DRB Application No.: <u>02-<del>A</del>01678 (SBP)</u>	Project # <u>1002327</u>
Project Name: <u>ALAMEDA BUSINESS PARK</u>	EPC Application No.:
Agent: <u>Rick Bennett Architects</u>	Phone No.:

## DEVELOPMENT REVIEW BOARD TRANSPORTATION DEVELOPMENT Standard Comment Sheet

DRB-1002327

DEVELOPMENT REVIEW BOARD--SPEED MEMO

**1 SITE PLAN**  
1"=20'

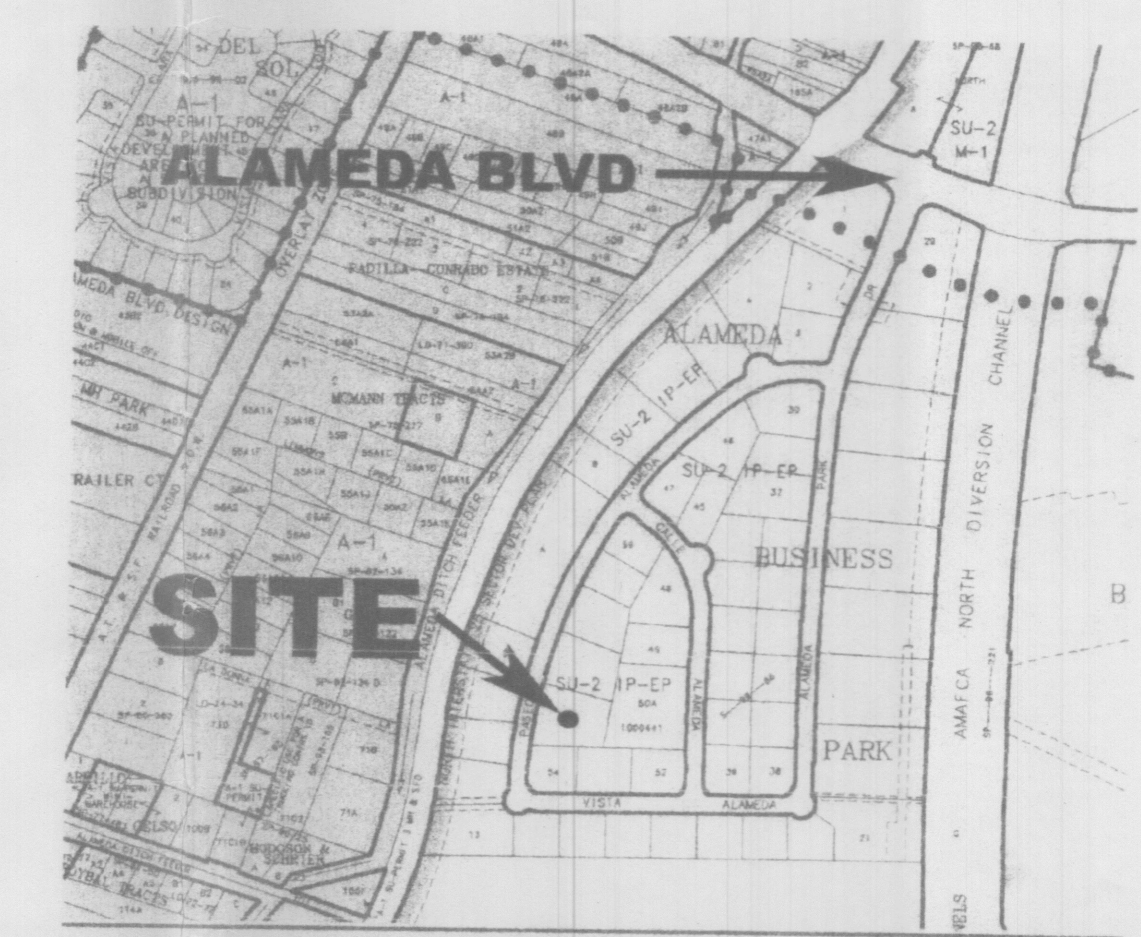
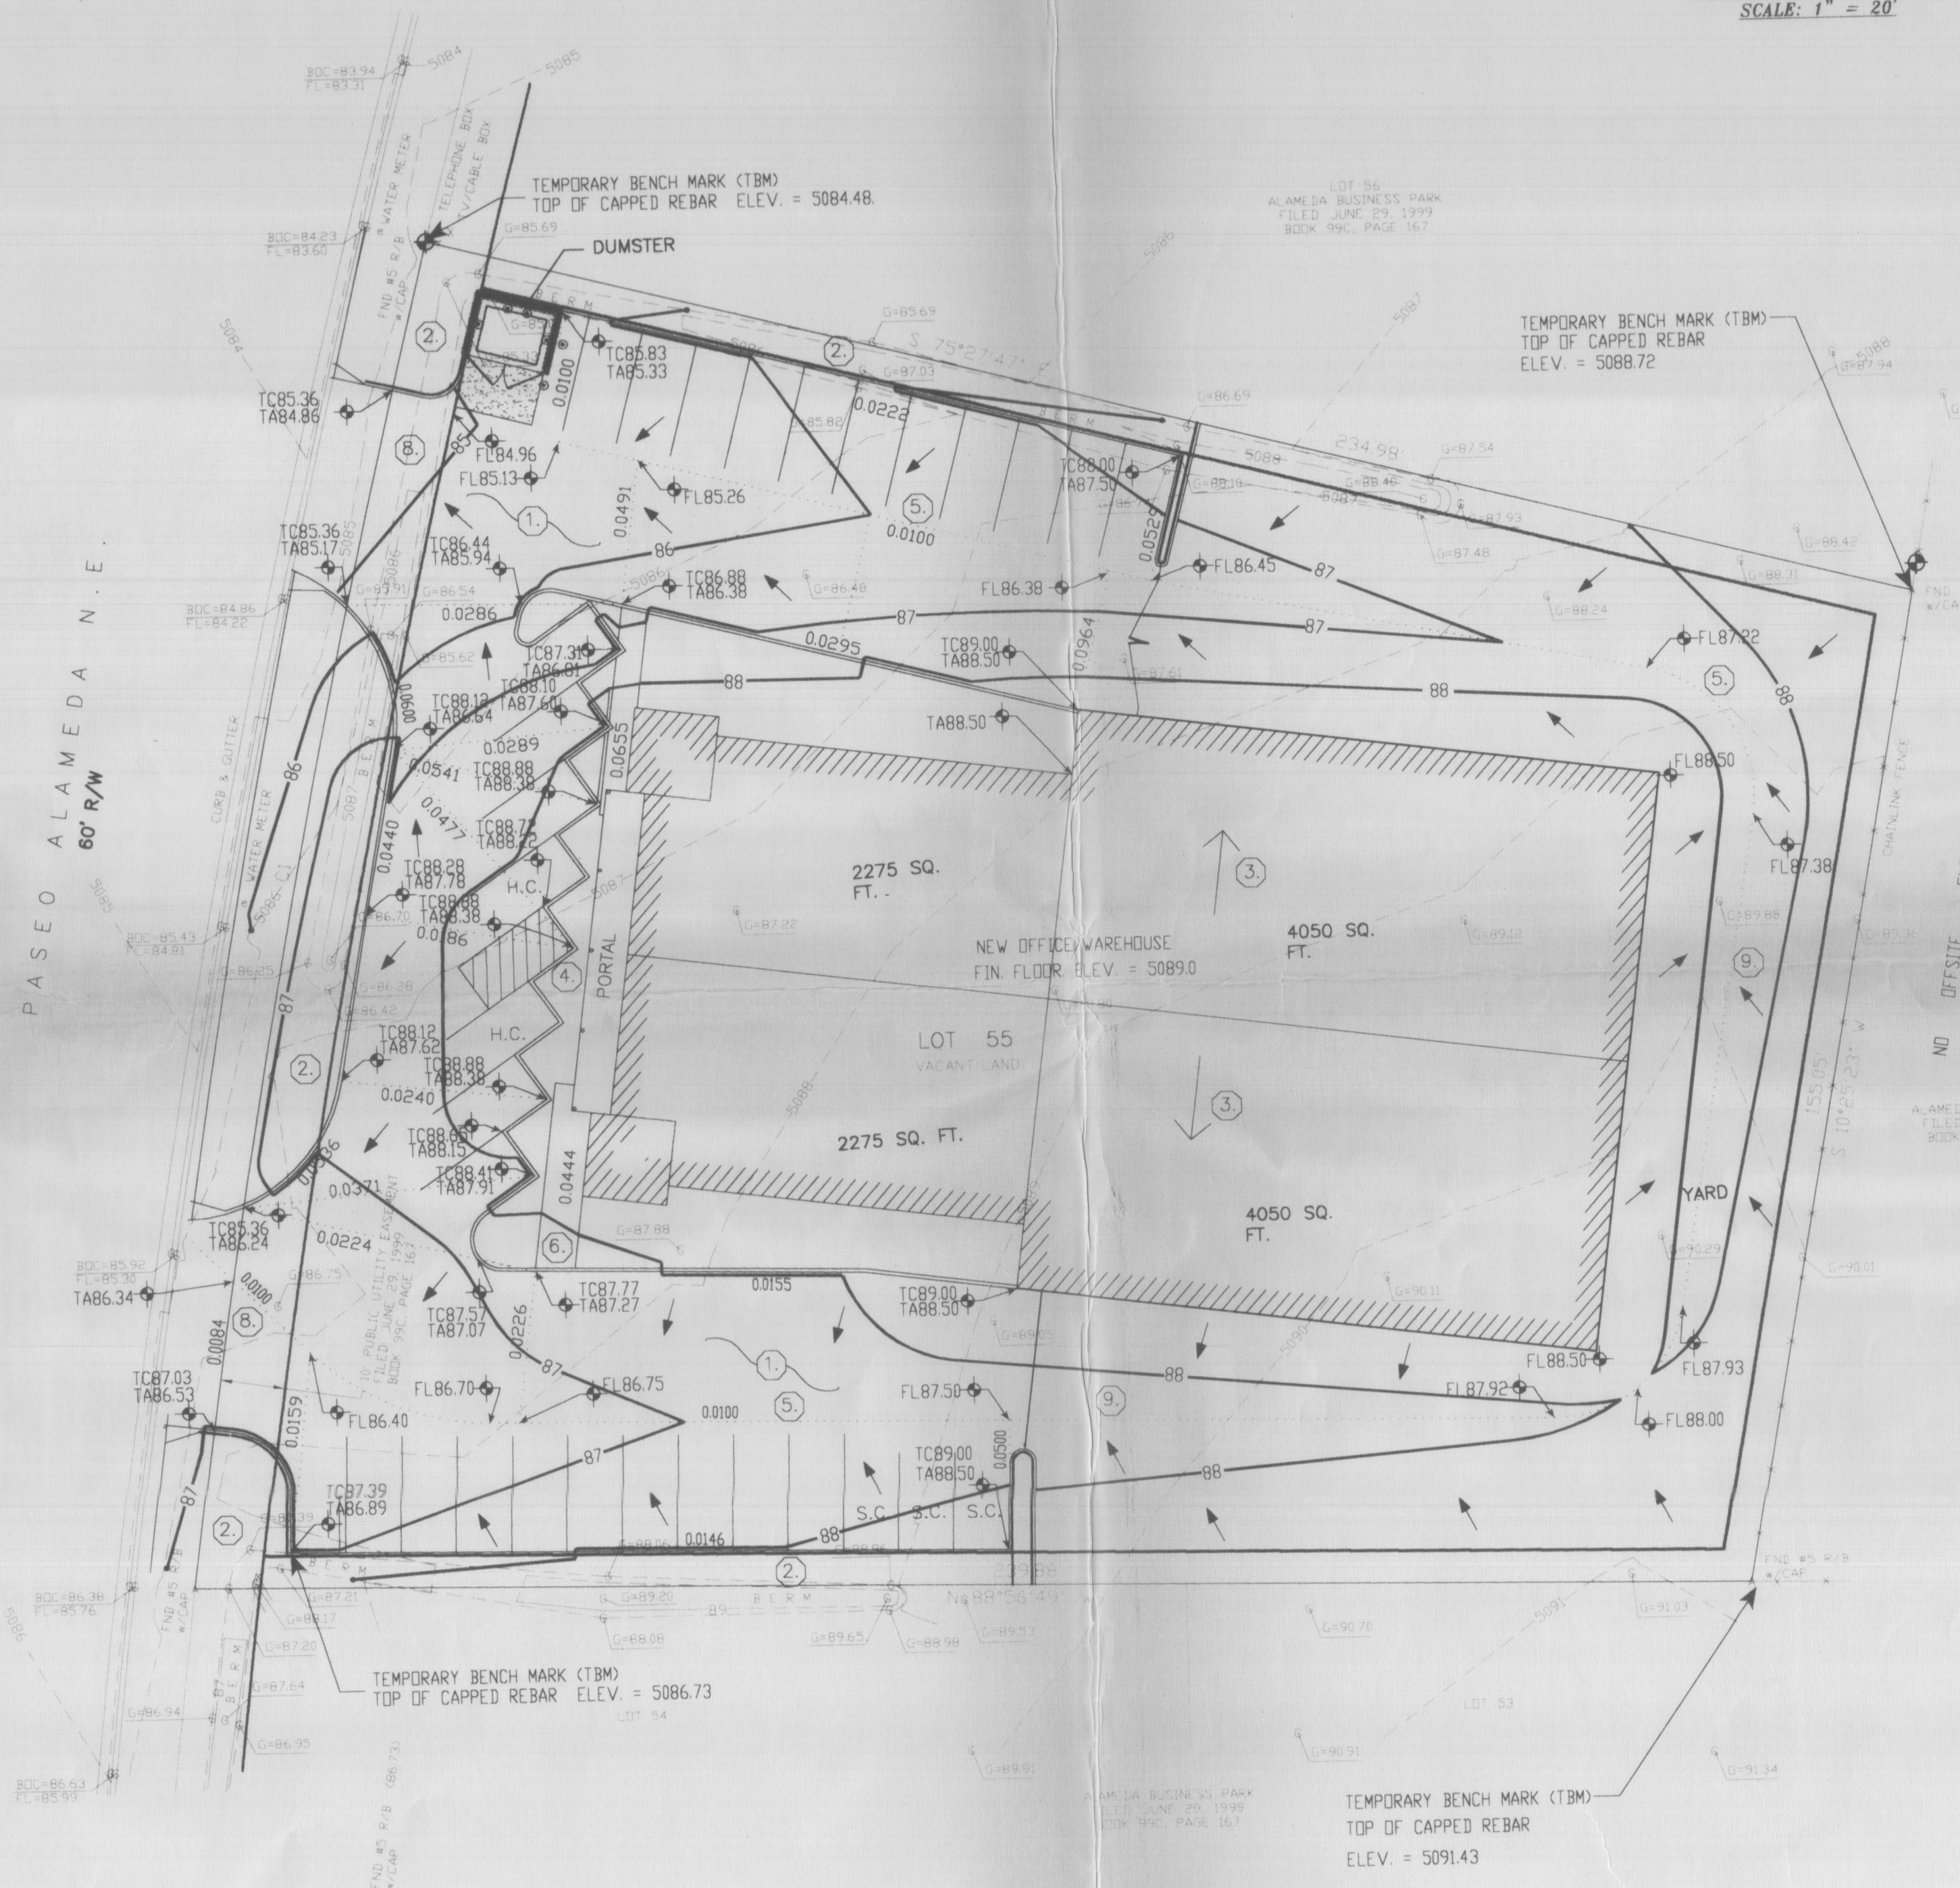
- Reference COA STD DWG 2425 for the proposed drivepads located at Paseo Alameda.
- Identify the Delivery Vehicle Route. One-Way circulation (pavement markings and signing) will be needed for the east side of the proposed building.
- Provide parking stall dimensions and wheel chair ramp is in question for ADA parking stall.

• Any sight distance problems due to landscaping? Verify by drawing site triangle (AAS#TO)

Additional Comment relative to the Landscape Buffer requirements contained in the North I 25 Sector Plan for industrial development:

1. A 10' wide landscape buffer is required along all arterials & collectors.

2. In addition, a 6' wide (at least) landscape buffer along the side & rear property lines is required.

The SDP as submitted lacks clear identification of those requirements.

5. Parking space dimensions  
width missing

1 LANDSCAPE PLAN  
1"=20'

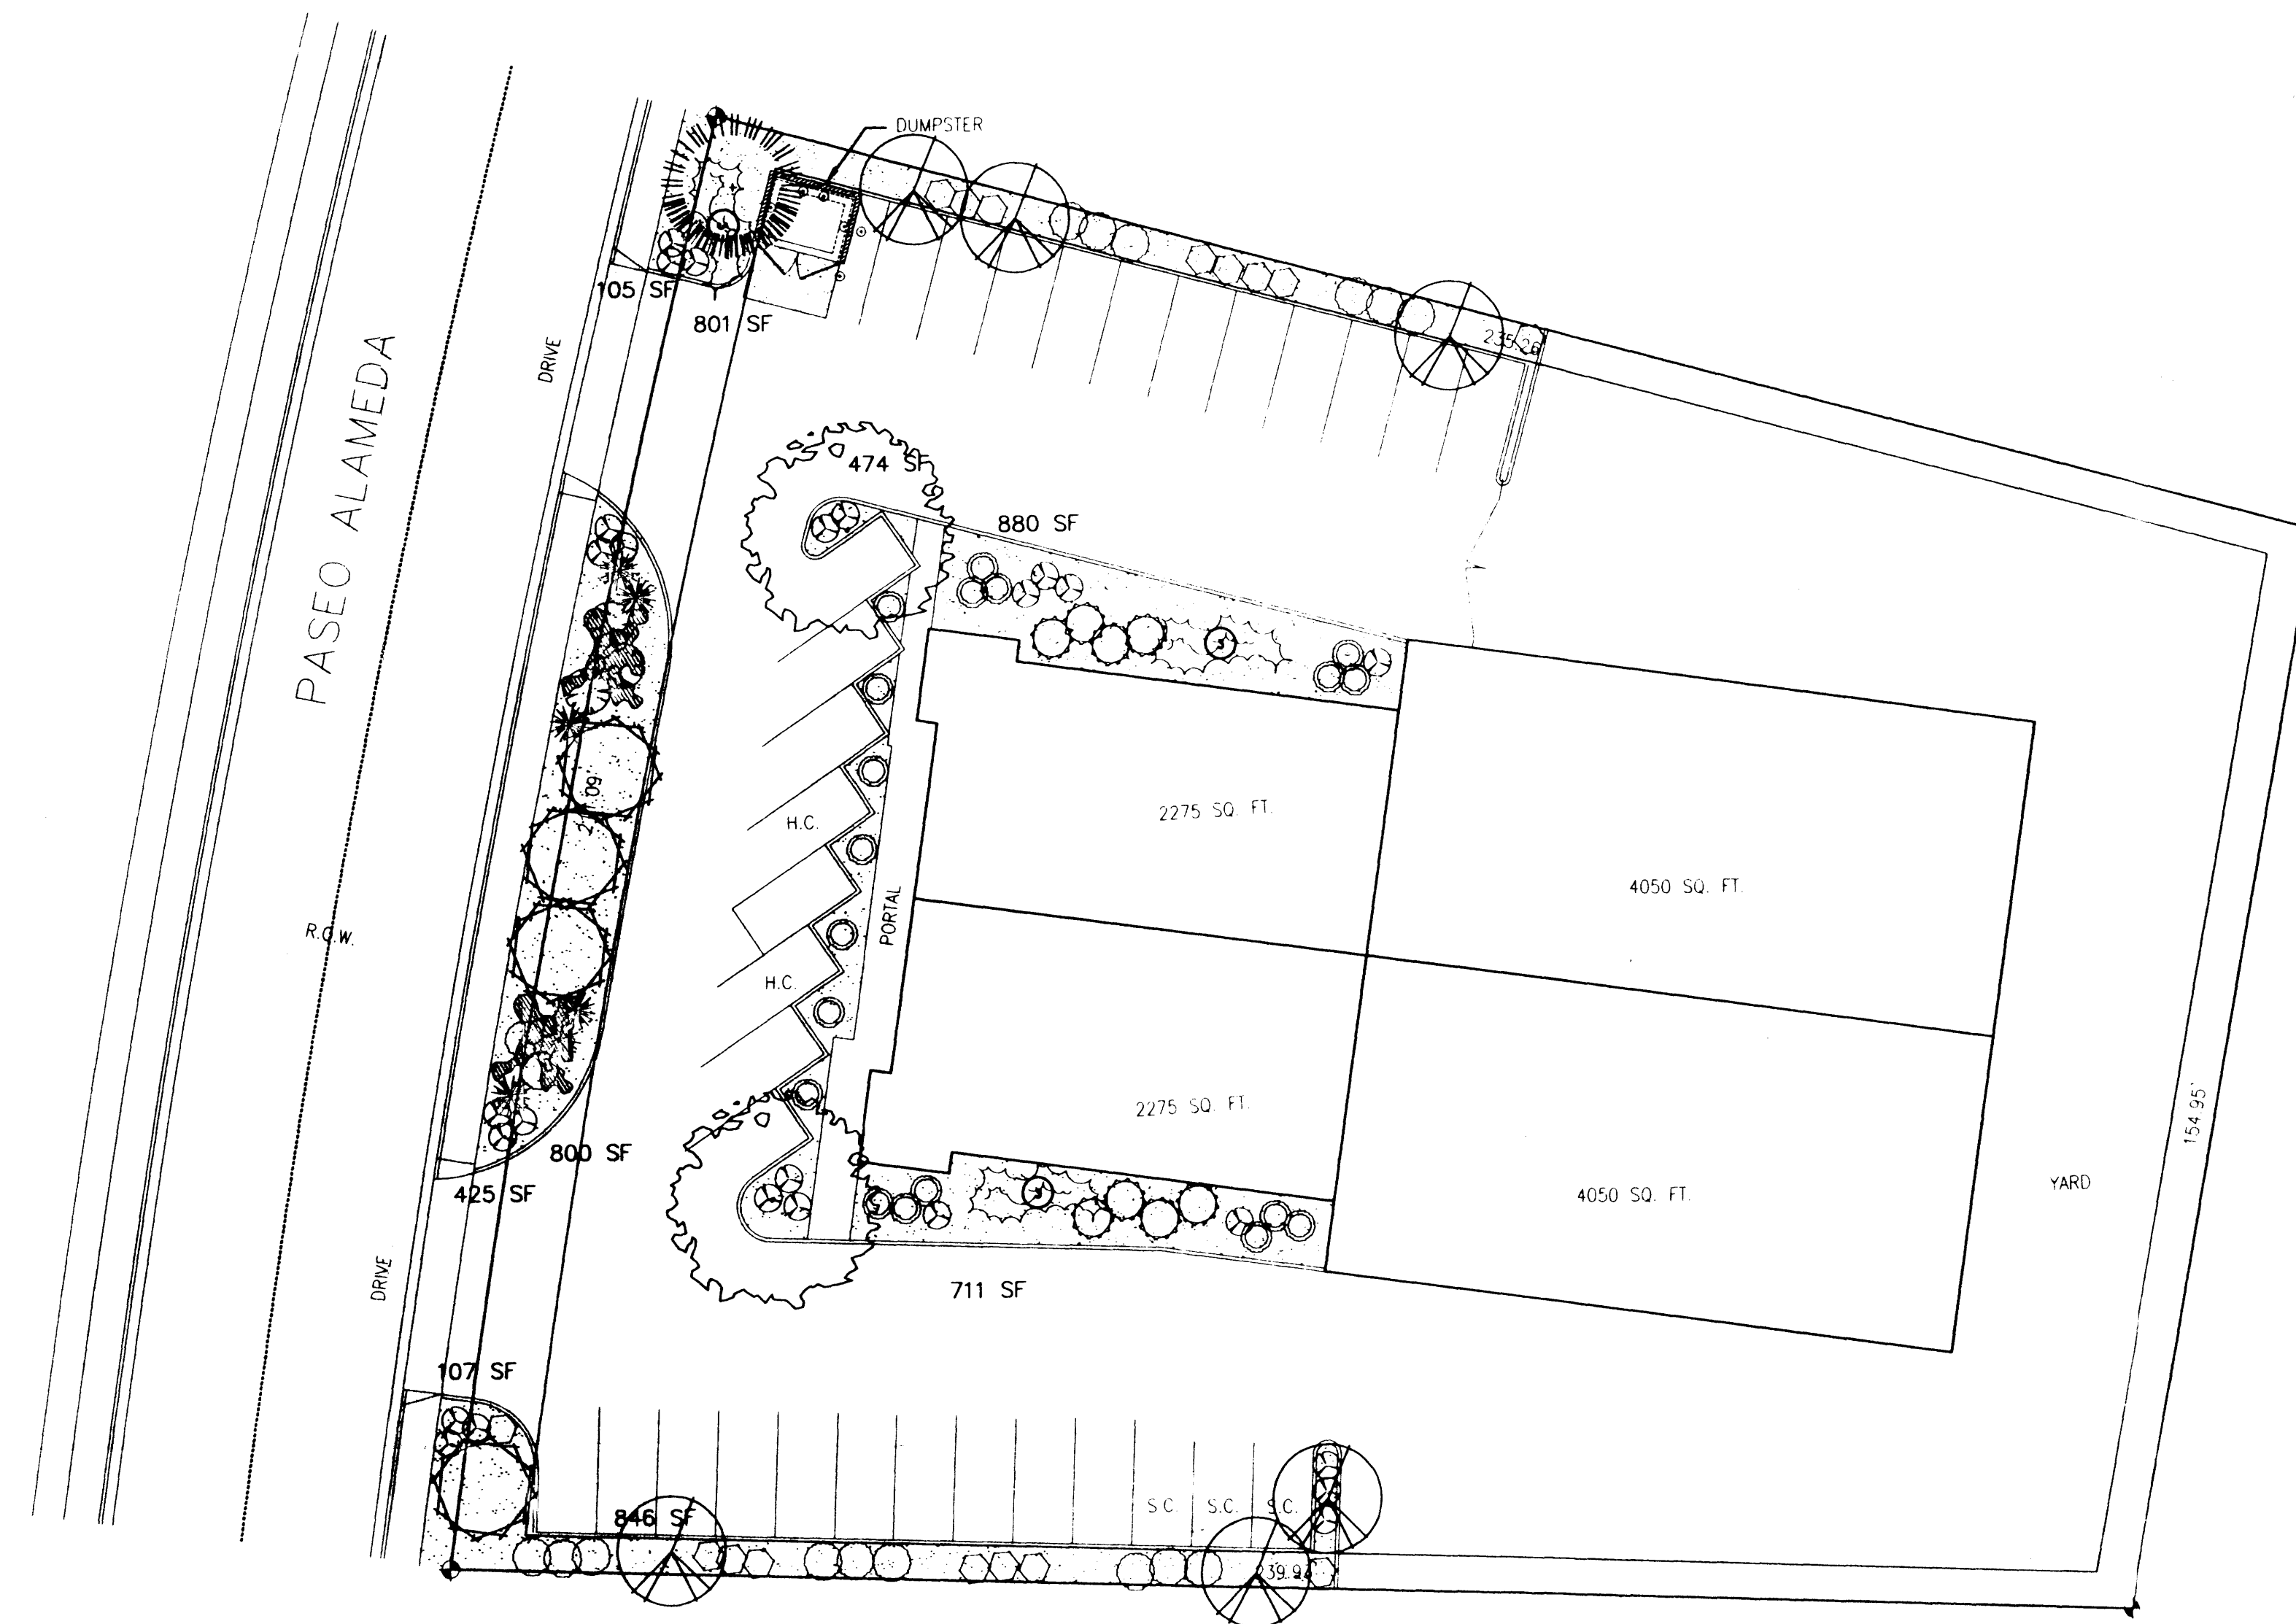
2. Landscape Plan Sheet

In comparing the plants & trees on this sheet with the City Plant List, these are our recommendations:

Consider the Texas Ash which is a medium water use ash as compared to others which are high water use.

Consider replacing the Austrian Pine, a high water use tree, with the Pinion or Bristlecone Pine, medium water use evergreens of similar size.

Consider replacing the Purpleleaf Plum trees, again high water use trees, with a comparable tree using less water.

Consider replacing the junipers, a high allergen, with another shrub causing fewer problems.

For future submittals, include  
existing & proposed placements  
on landscape plan
